February 23, 2026

**Re: Stillbrooke Homes at La Mirada Subdivision on Wymont Circle
Lots 2-6, 15-24, and 55-62
Erosion and Sediment Control Plan G19E004A_SB (SWQ-2026-00008)
Engineer's Stamp Date – 1/7/26**

STILLBROOKS HOMES, INC.
LA MIRADA SUBDIVISION
SWPPP NOTES

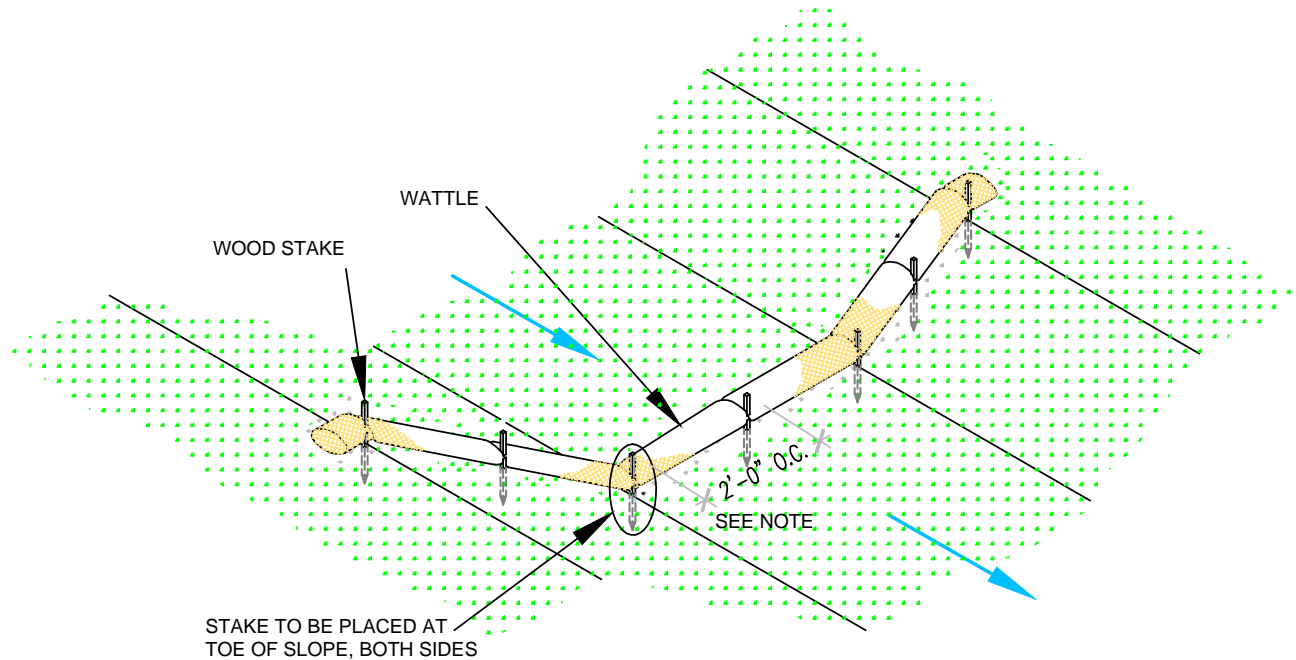
3. Replace the city standard notes on sheet 3 with the most recent version (attached). Add city BMP details for Stormwater Silt Fence (SWSF) and Cutback Curb (CBC) to better adhere to the NMED requirements in CGP 9.6.1.c.i, where it says paraphrased, "the SWPPP must also describe design specifications, construction specifications, maintenance schedules, and criteria for inspections of the BMPs."

SHEET:
9

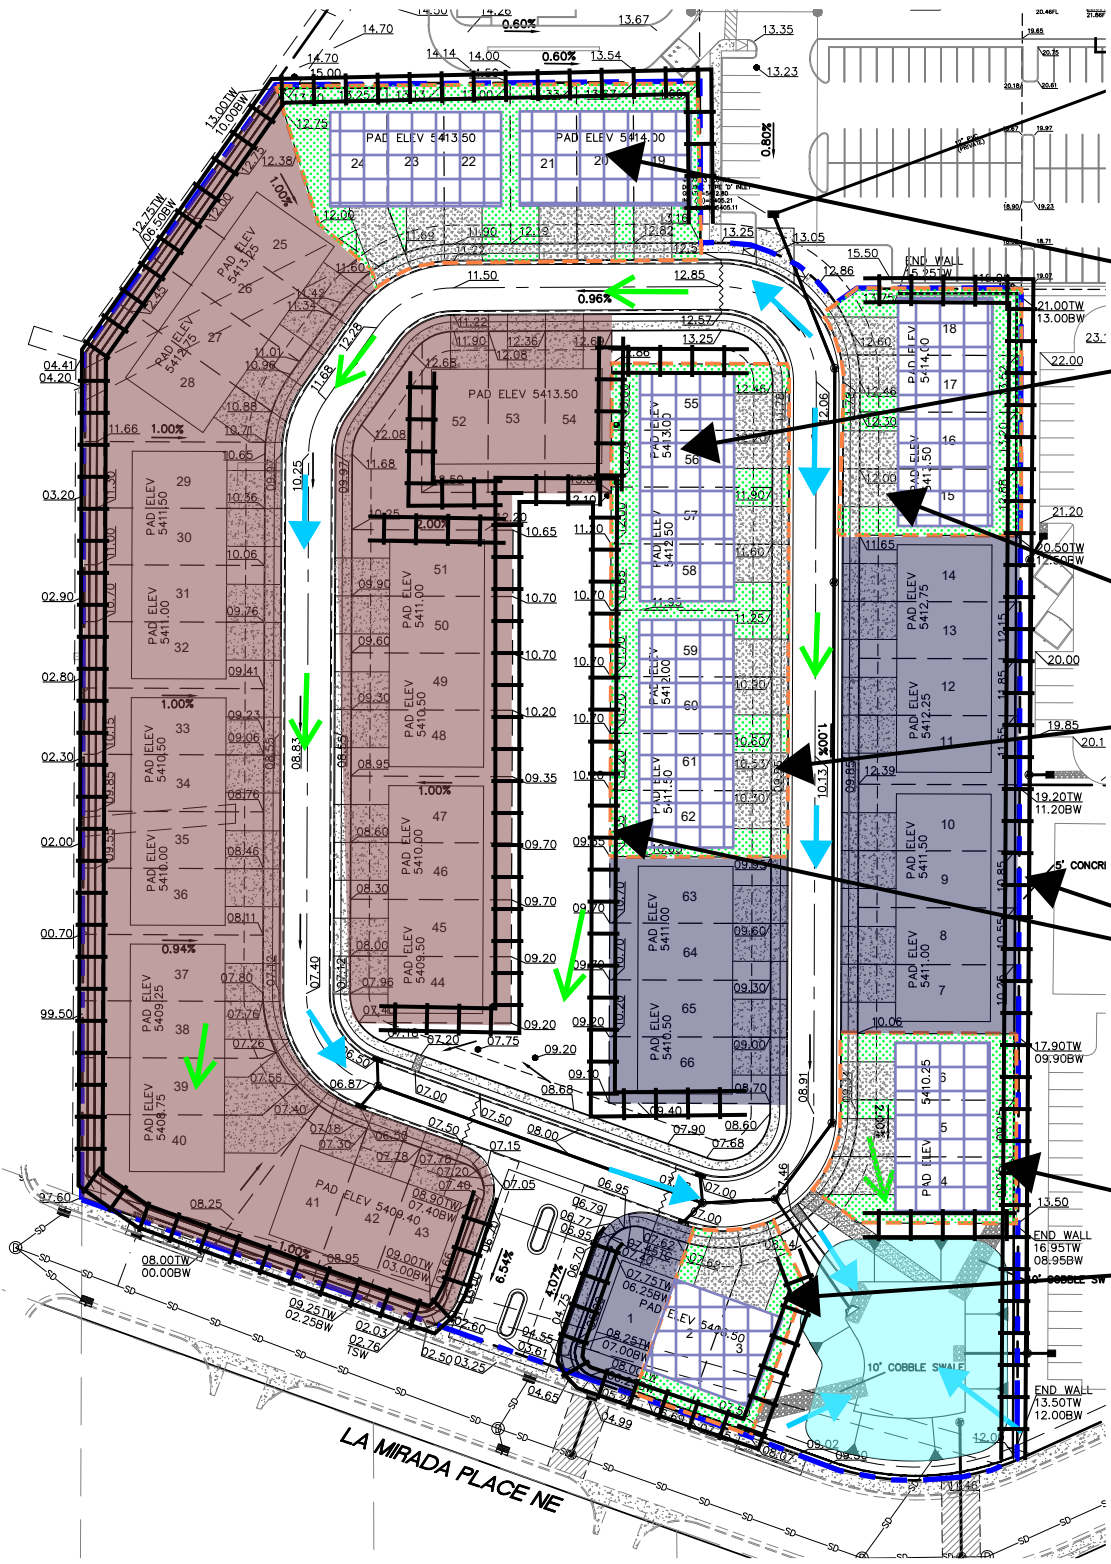
Sheets 9 and 10 incorrectly show areas belonging to other operators that are unrelated to Stillbrooke's property. This ESC Plan should not include lots where Twilight Homes has already built and sold homes, as they no longer qualify for CGP coverage. Similarly, AMREP Southwest, Inc. (NMR10044Z) never owned these lots. Wymont, LLC (NMR10044X) has owned AMREP's lots since they were first platted; last year, they were sold to Amreston Homes LLC, which does not have permit coverage. Please avoid highlighting lots that are irrelevant to Stillbrooke's CGP coverage. Focus the ESC Plan only on the lots for which Stillbrooke Homes is seeking CGP coverage. Twilight Homes owns and maintains CGP coverage under NPDES ID # NMR1006BR for all lots listed in the table on sheet 4 that Stillbrooke Homes has not already purchased. Using standard real estate terms, describe Stillbrooke's purchase of each lot from Twilight and the

subsequent sale of finished houses to homeowners as the start and end of Stillbrooke's CGP coverage for each lot. Moving the table from sheet 4 to sheet 9, with separate columns for purchase and sale dates, would be helpful.

4. The standard BMP for residential lots is a Cutback Curb (CBC), where sidewalk construction is delayed until after the house is built. Stormwater Silt Fence (SWSF) or Compost Filter Sock are acceptable alternatives to CBCs, especially when sidewalk and HC Ramps prevent the use of CBC. A silt fence is suitable on the sides of the property that do not face the street. However, the existing 0.22 ac-ft post-construction SWQ pond only provides a fraction of the retention volume required by CGP 2.2.12 and city ordinance § 14-5-2-12(b)(3). The 10-year volume of 1.59 ac-ft (per the 2/8/22 Wymont Master Drainage Plan) is necessary for the sediment basin according to city ordinance § 14-5-2-12(b)(3), because the peak 100-year flow rate of 59.98 cfs exceeds the 50 cfs limit. Please update the stormwater controls and highlighting on sheet 9.
